EPC STORMWATER REVIEW COMMENTS ARE SHOWN IN ORANGE BOXES WITH BLACK TEXT

THE LANDINGS OF DENMARK FILING NO. 2 COUNTY OF EL PASO, STATE OF COLORADO CONSTRUCTION PLANS

Construction Drawings (PlansProfiles)_v1.pdf Markup Summary

O'STEEN COURT
SCALE: HORIZ. 1" = 50'
VERT. 1" = 5'

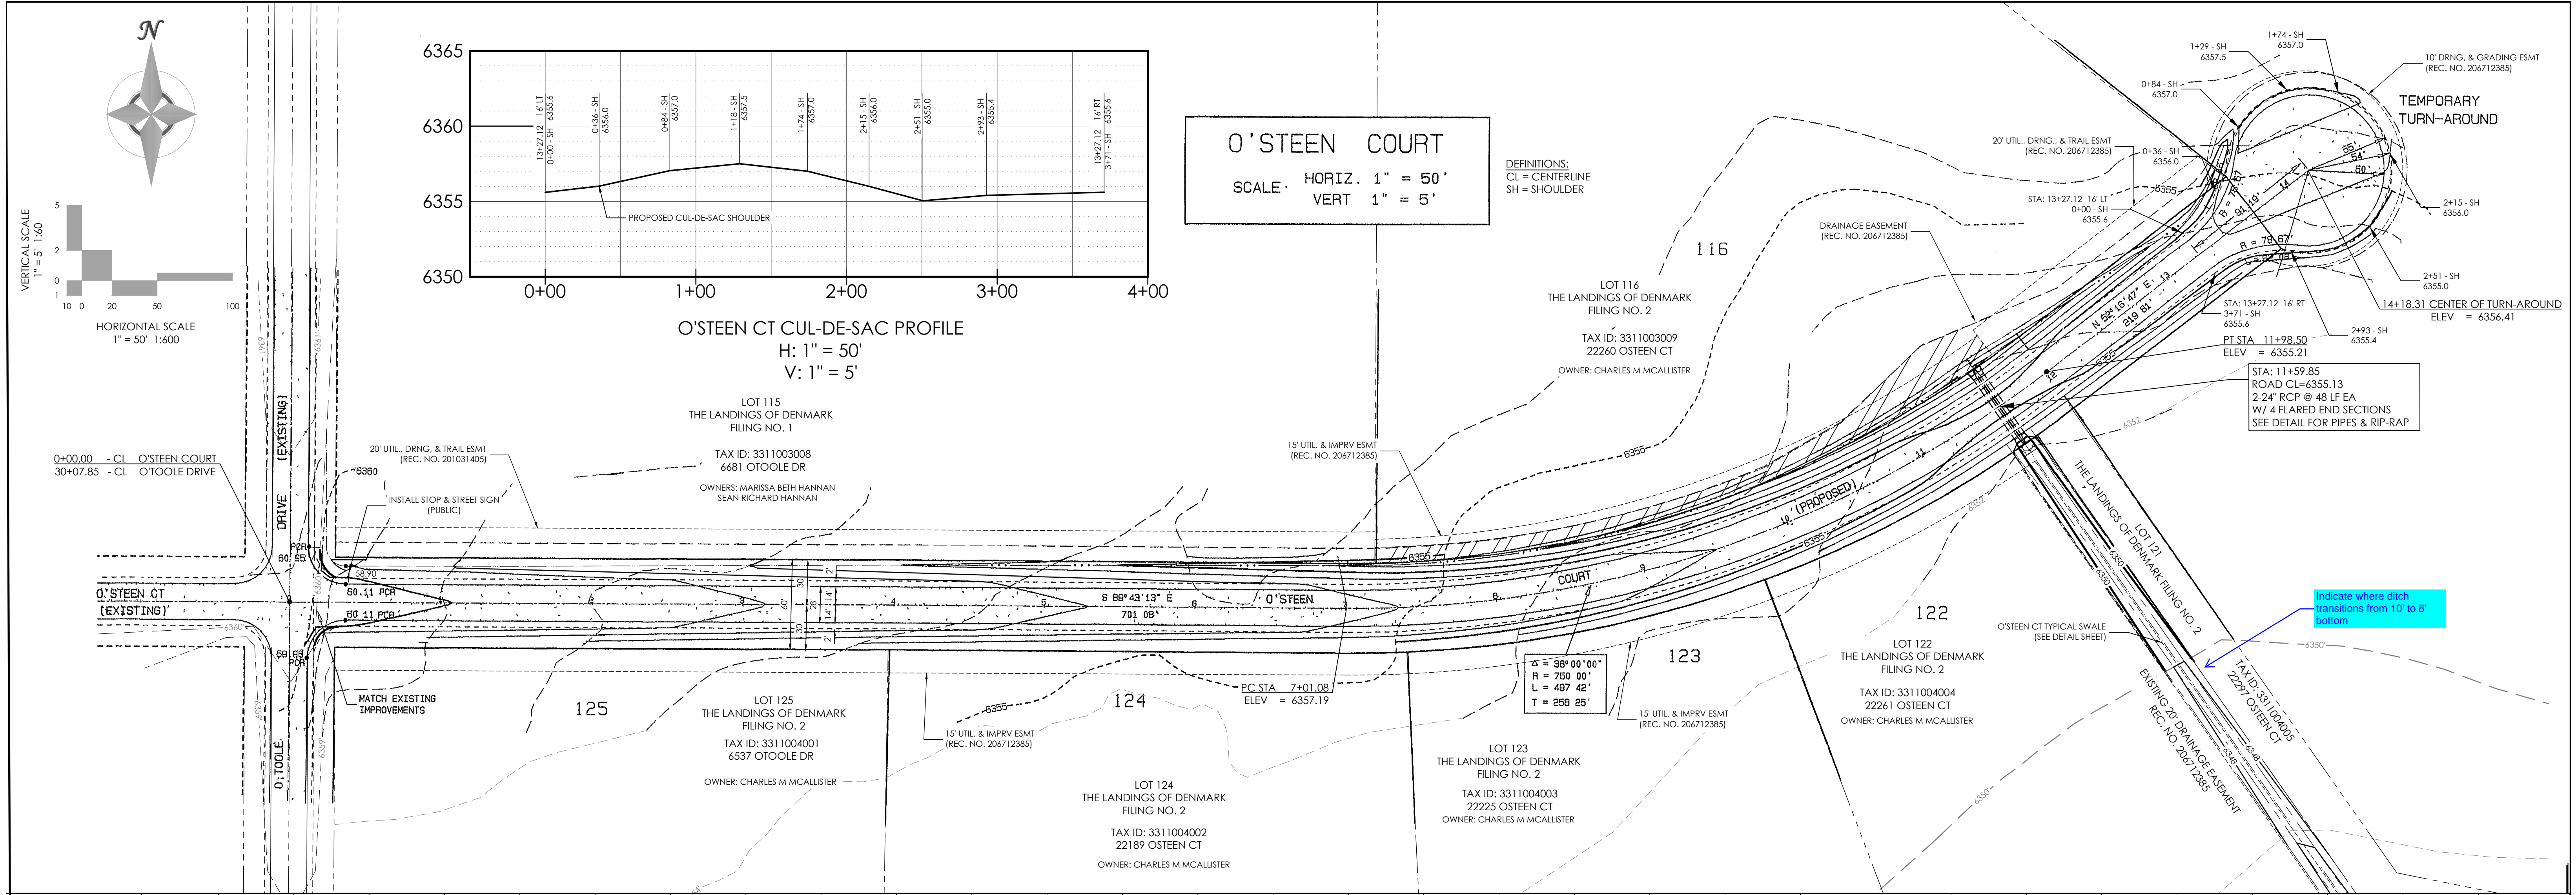
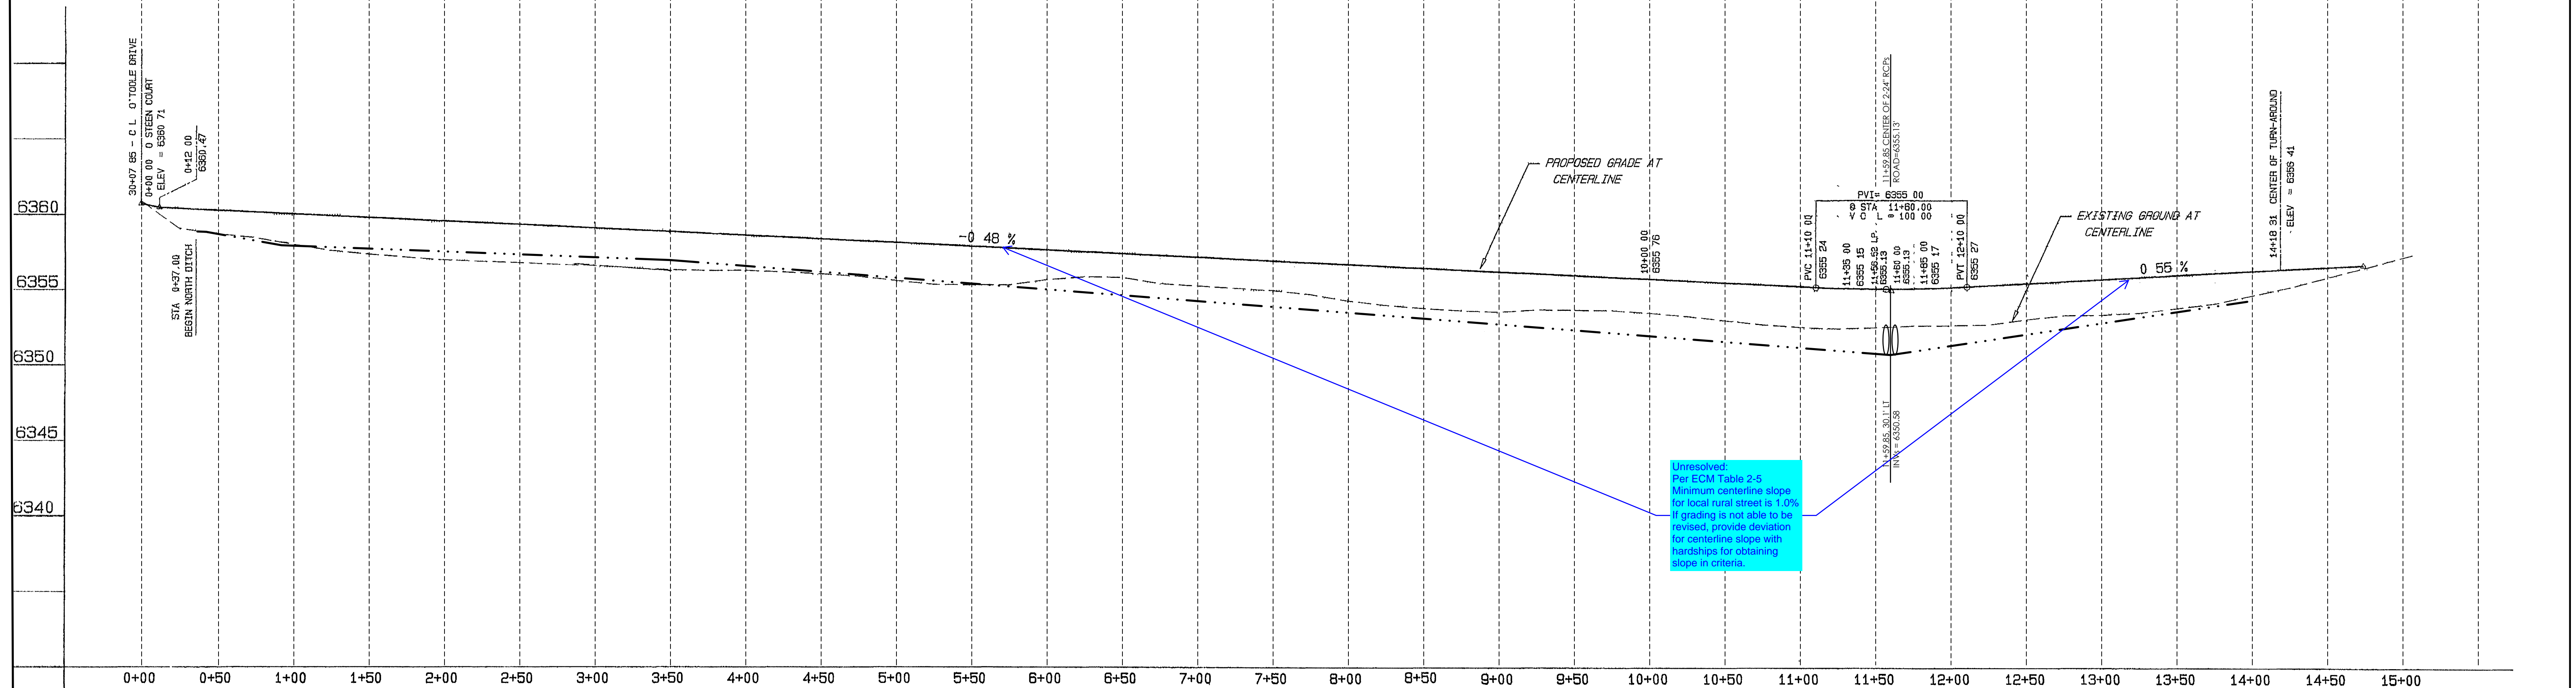
Per ECM Chapter 3.3 only RCP Class 3 is allowed in the county right-of-way. Please revise drawings and see comment on drainage letter.

Provide grading for swale to convey flow to existing culvert

Provide profile around cul-de-sac but

Provide profile of culvert crossing, including 100-yr hgt

Per ECM Table 2-5 Minimum centerline slope for local rural street is 1.0%

Grading needs to tie to existing ground

Per ECM Table 2-5 Minimum centerline slope for local rural street is 1.0%

ROCK RIPRAP ENERGY DISSIPATOR DETAIL  
NOT TO SCALE

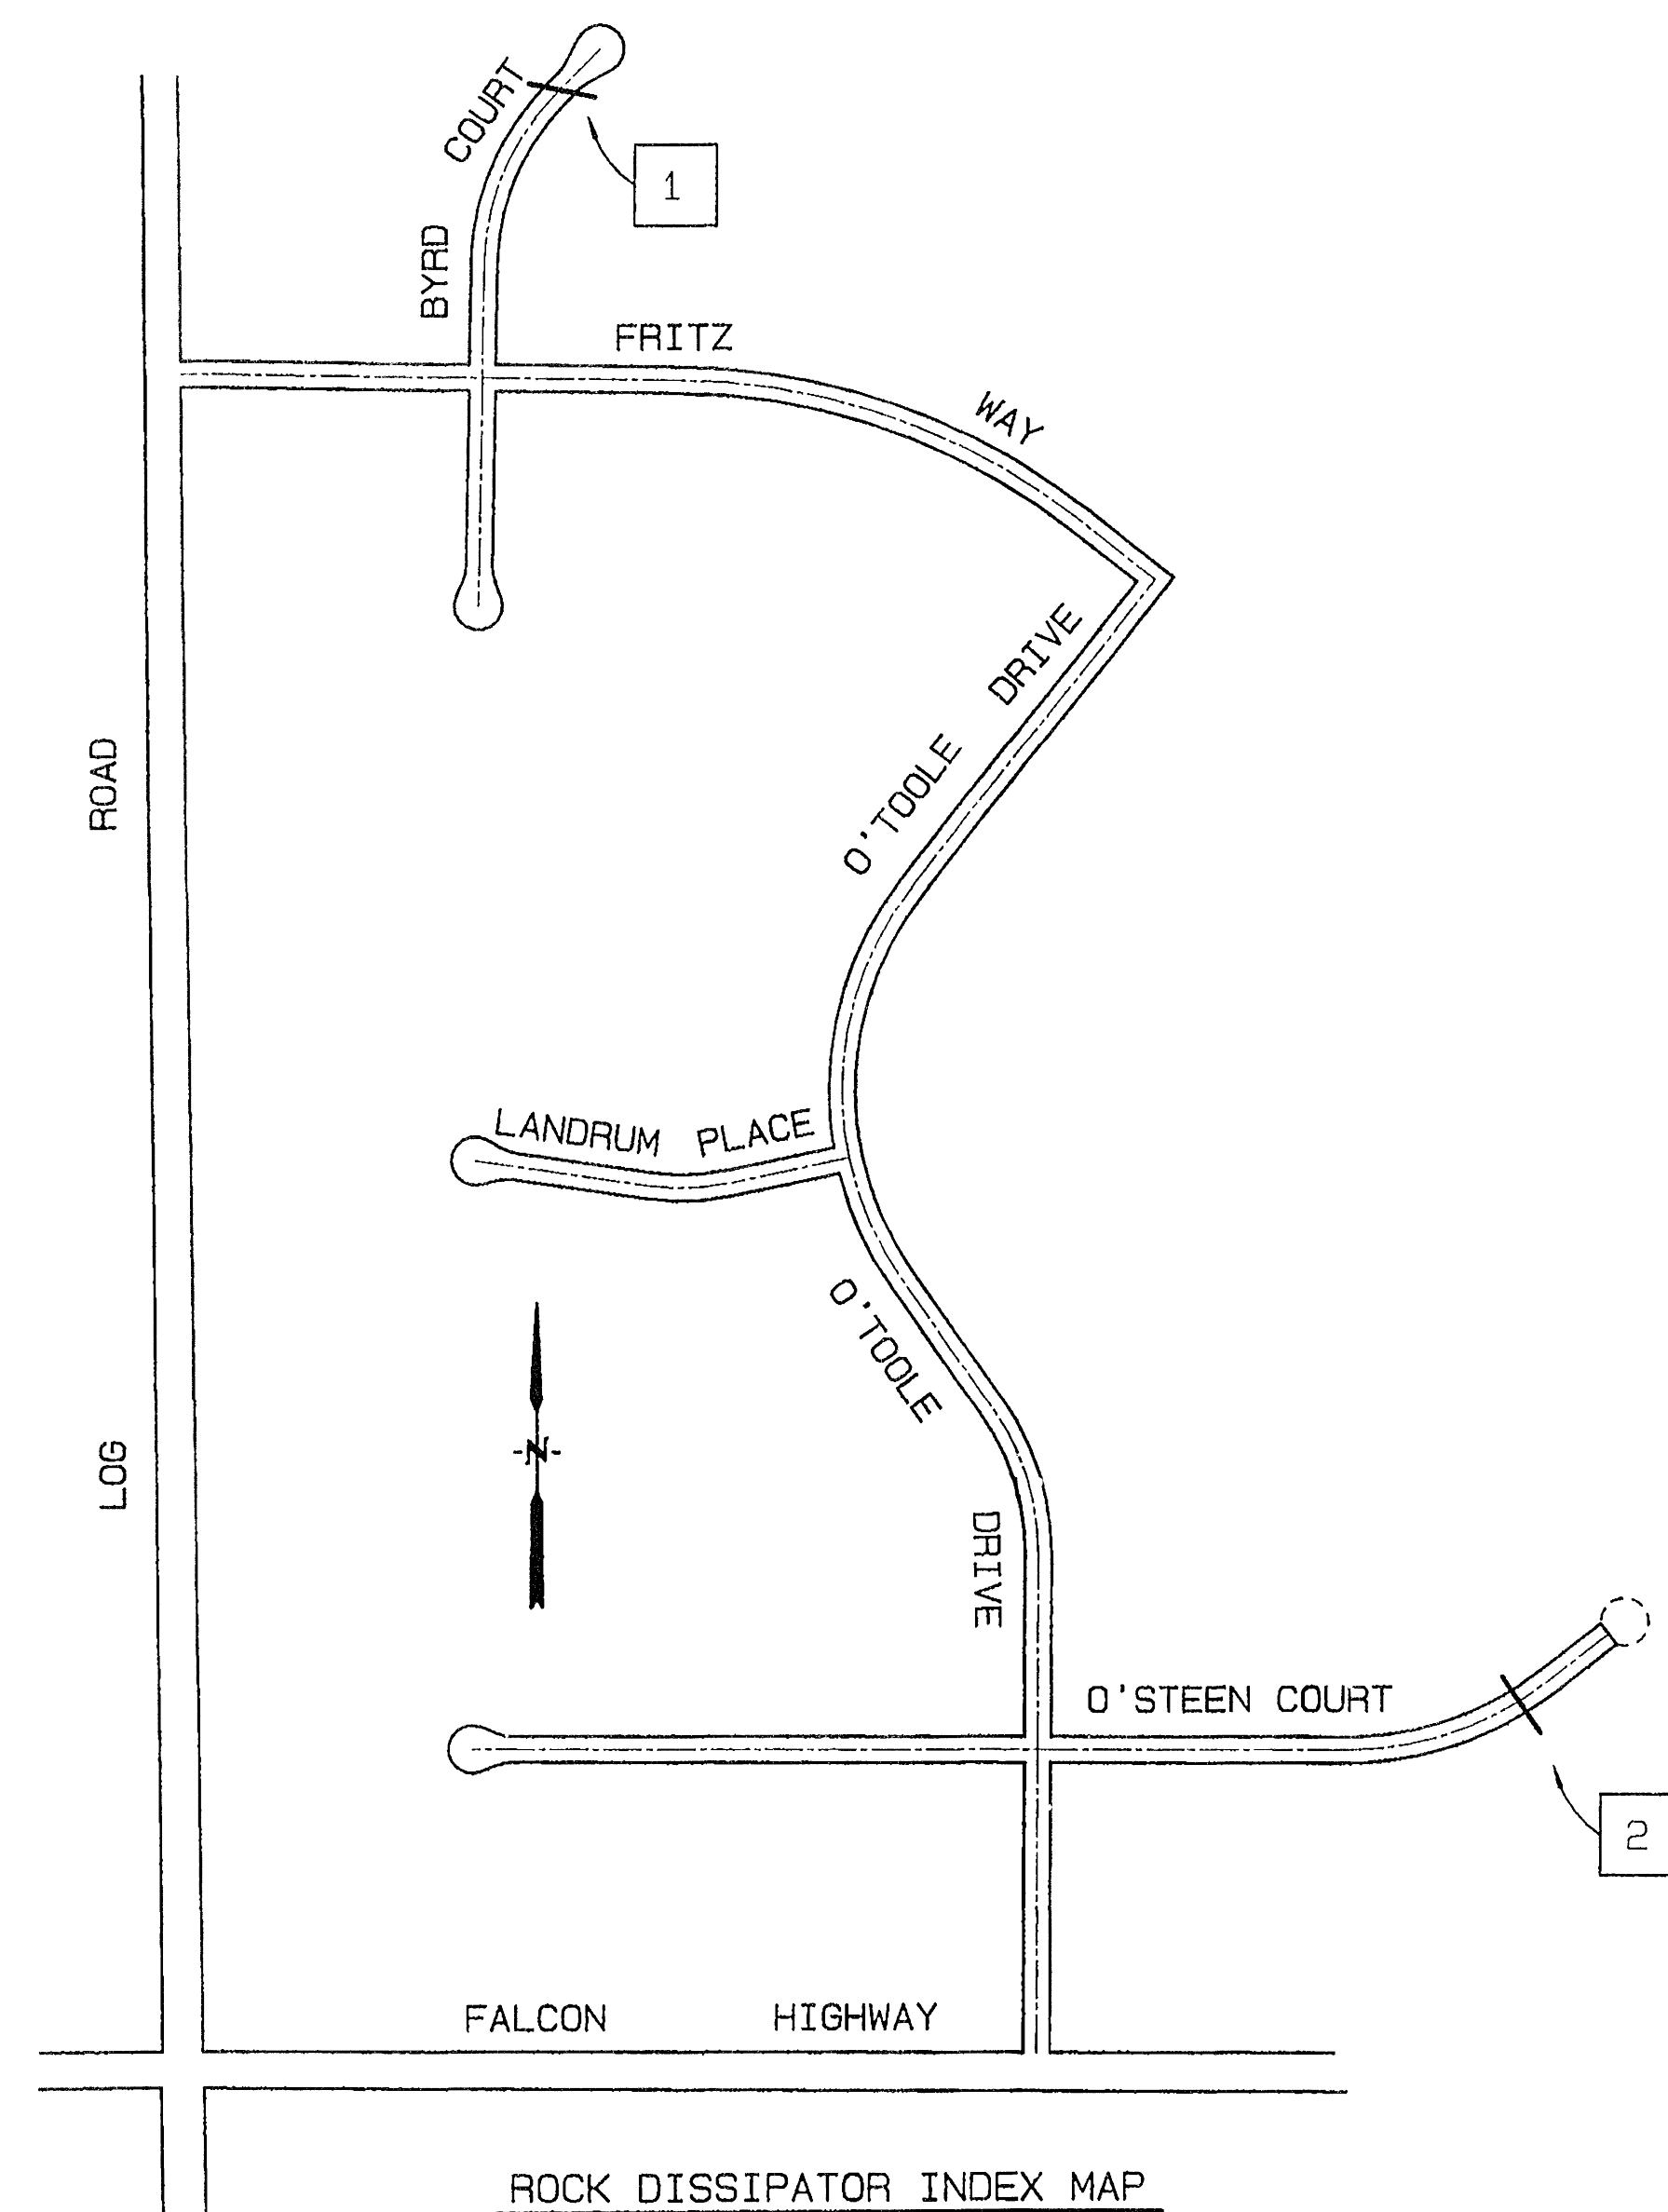
Please show an accurate detail and dissipator sizing for triple 24" pipe and double 30" pipe

Provide riprap gradation table and note that CDOT Section 506 Requirements apply.
